**CITY OF PORTLAND, MAINE
DEVELOPMENT REVIEW APPLICATION
PLANNING DEPARTMENT PROCESSING FORM**

Brackett St Veterinary Clinic

192 Brackett St

DRC Conditions of Approval

**1** FIRST FLOOR AND SITE PLAN  
SCALE: 1/4" = 1'-0"

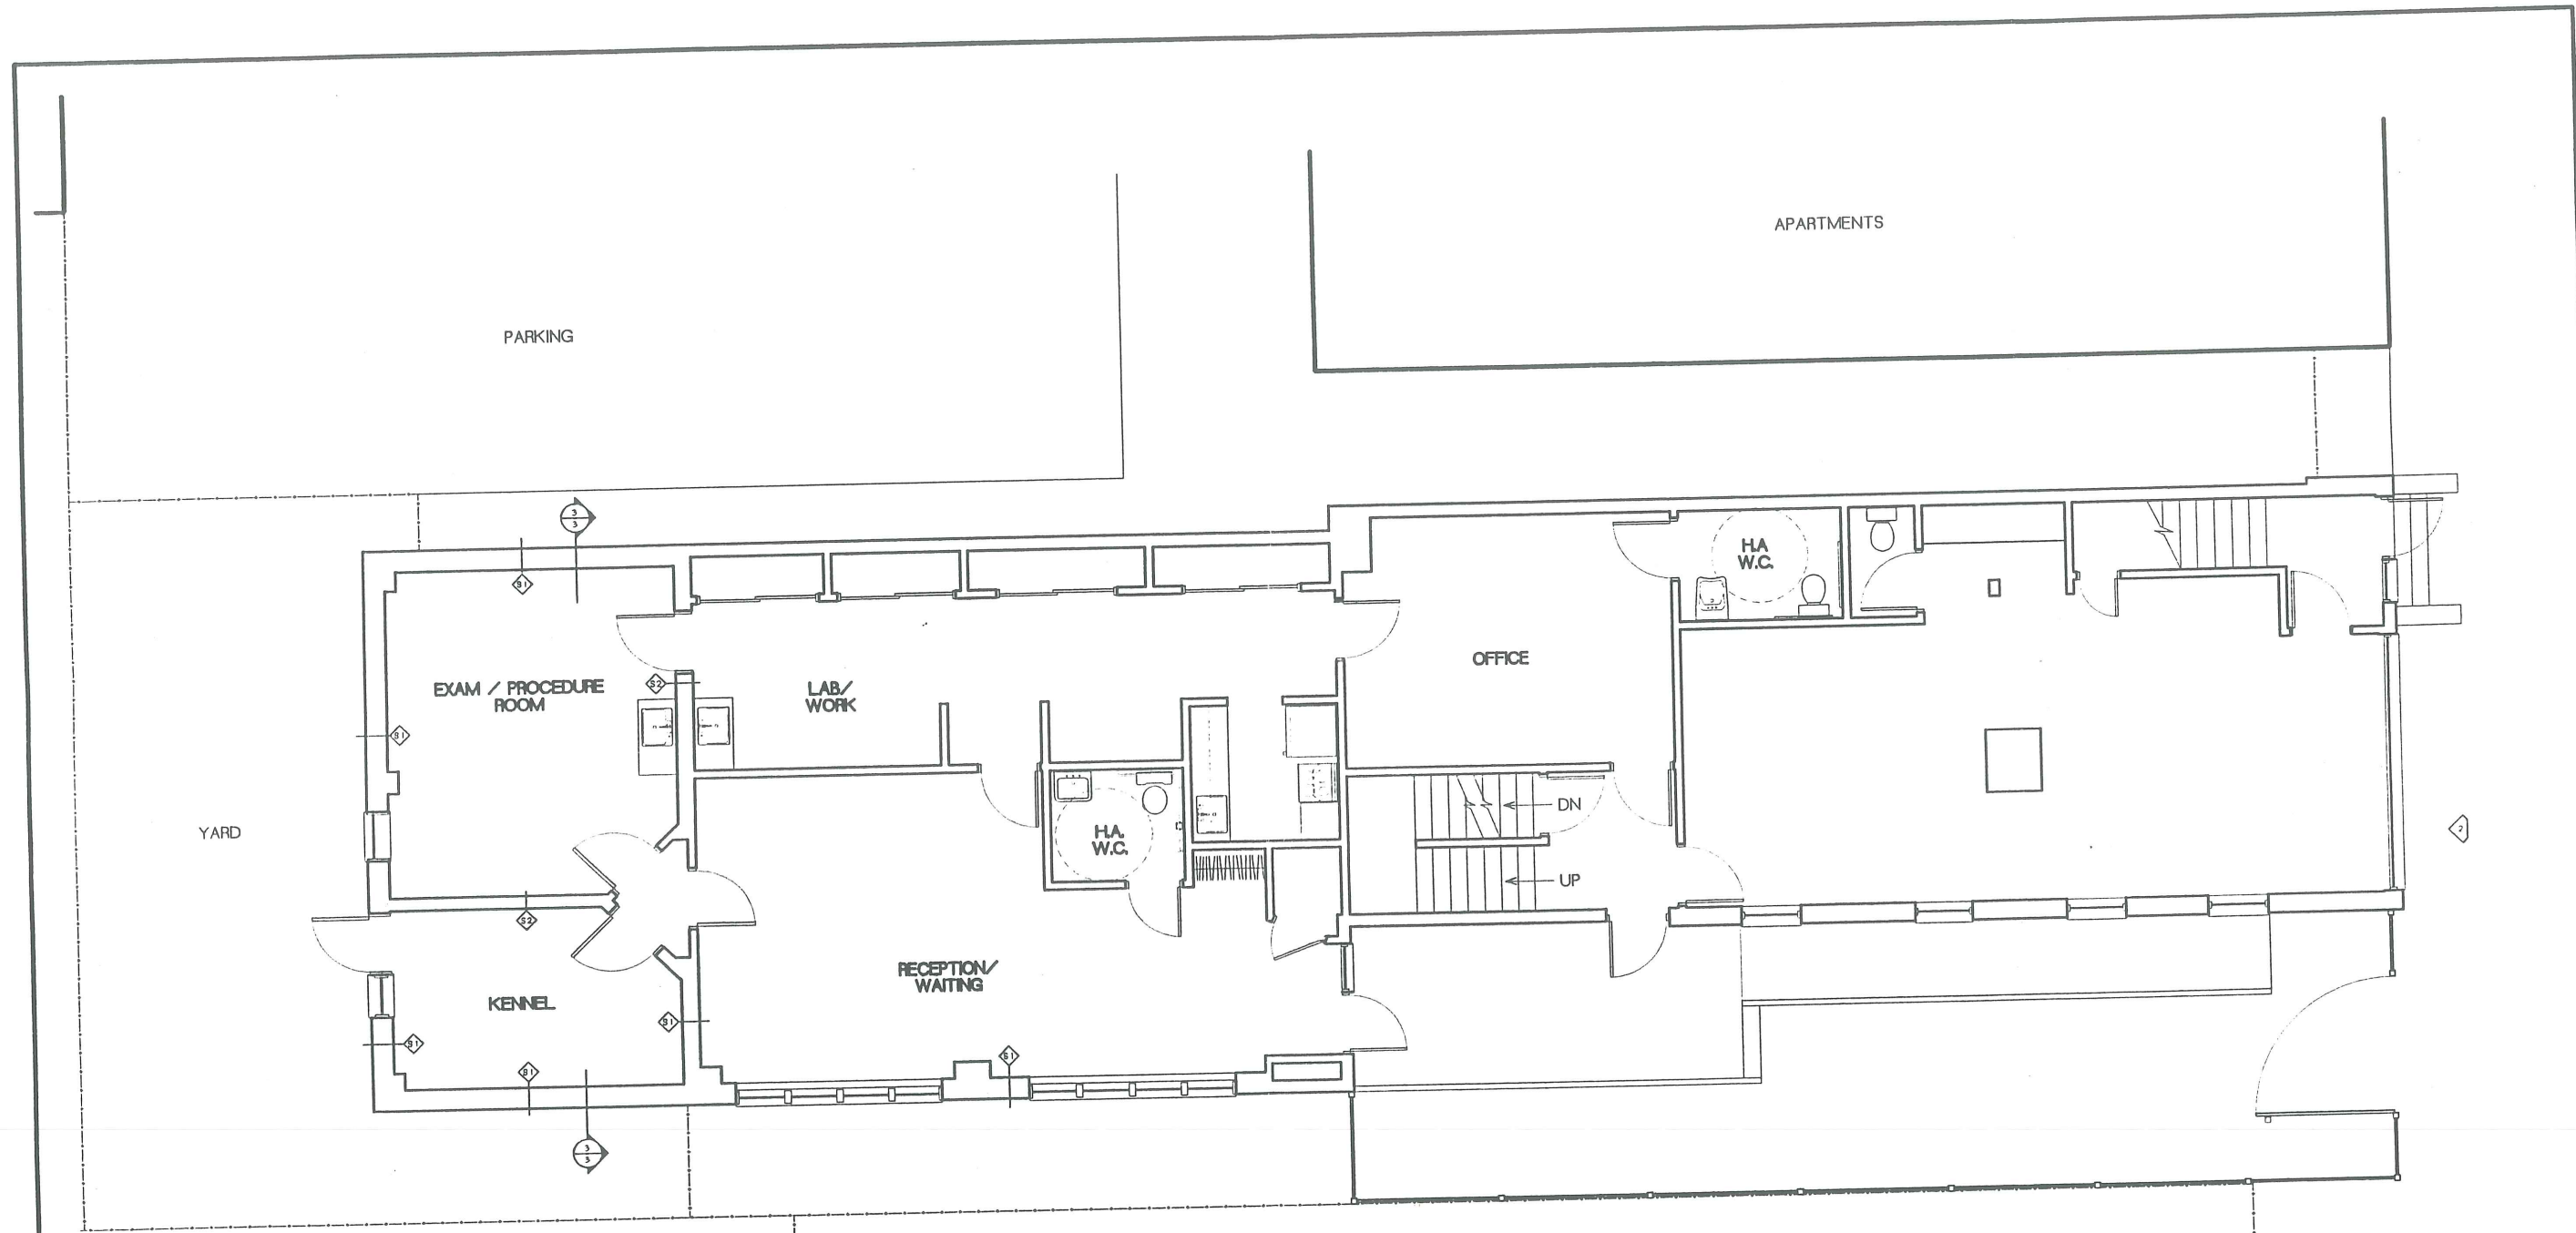
- that the window be removed within the kennel area
